TOWN AND COUNTRY PLANNING ACT 1990

SECTION 73A CONTINUATION

Reference: H17-0167-24 **Date of Decision:** 18th April 2024
Applicant: Mr & Mrs S Huntsman
72 Reservoir Road
Surfleet
Spalding
PE11 4DH
Location: 72 Reservoir Road Surfleet Spalding
Description: Proposed Dwelling - approved under H17-0873-18. Modification of Condition 2 to allow amendments to previously approved plans

PROPOSED ELEVATIONS

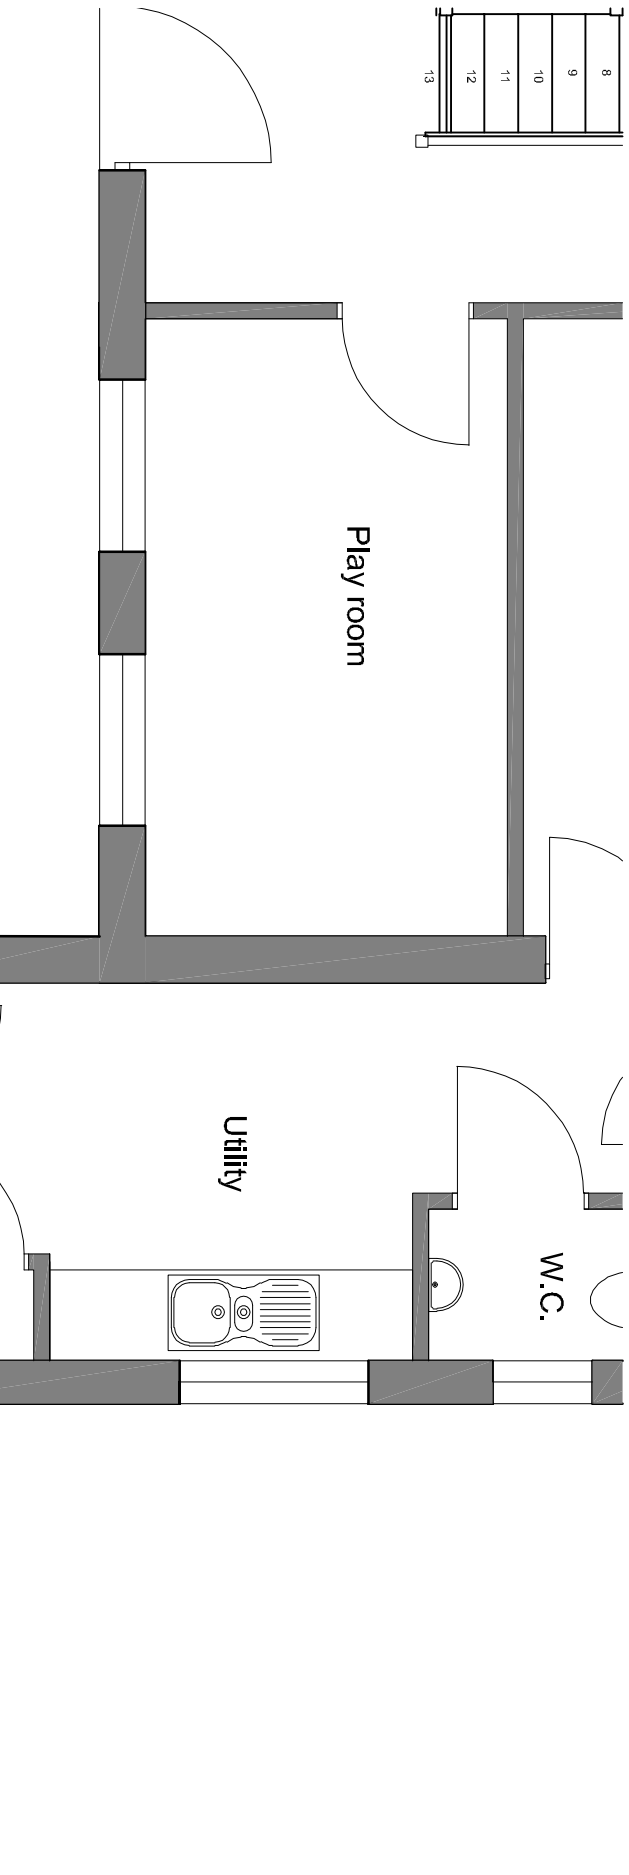
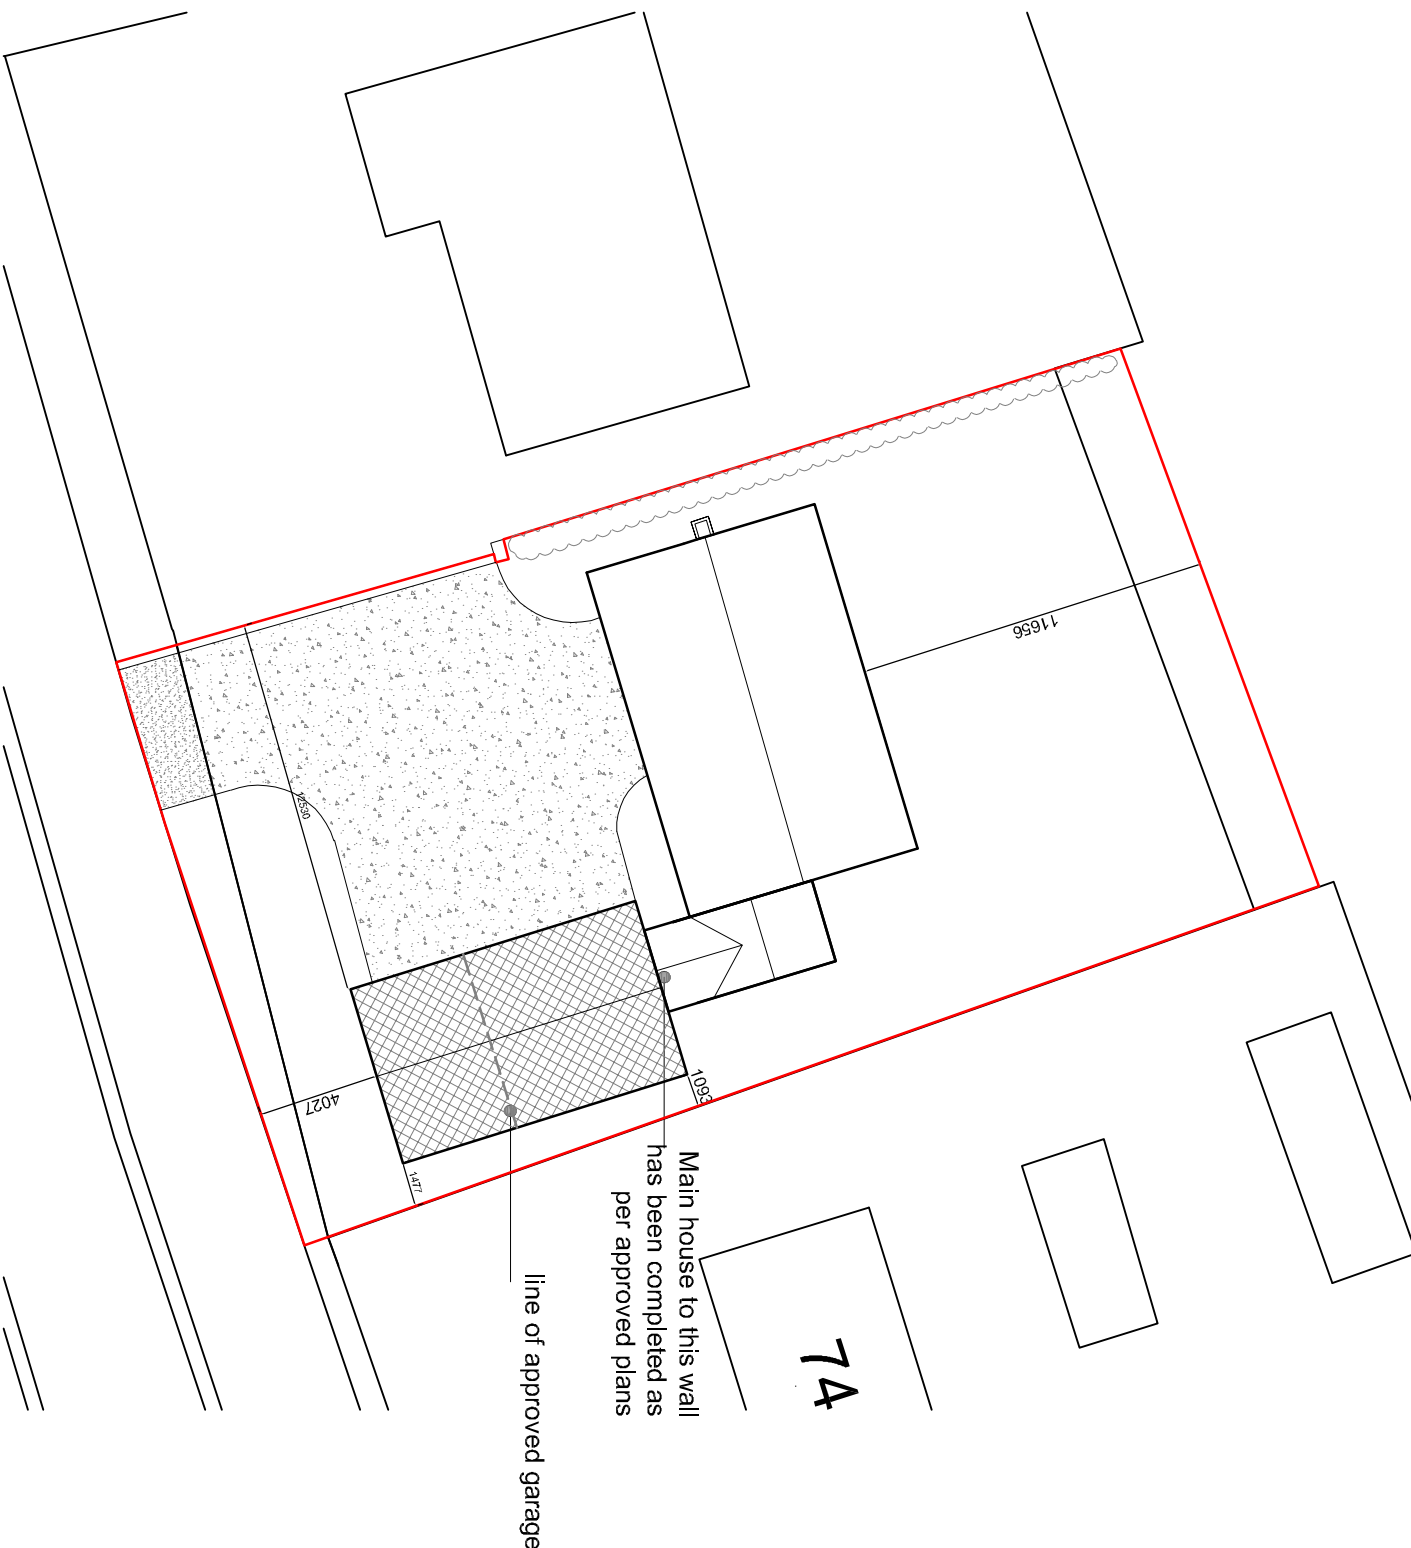
- 1 The proposed garage projection is considered to generate a material character and overshadowing impact on adjacent properties and the surrounding area. This is due to the significant increase in the length and height of the proposed building. The new dimensions of garage / office projection would create a material development precedent in the vicinity of the site by allowing a visually prominent two storey development adjacent to the highway that is sited significantly forward of other lines of frontage in the vicinity of the site. The building is therefore not considered to accord with Policies 2 and 3 of the South East Lincolnshire Local Plan, 2019, as well as Section 12 of the National Planning Policy Framework, December 2023.
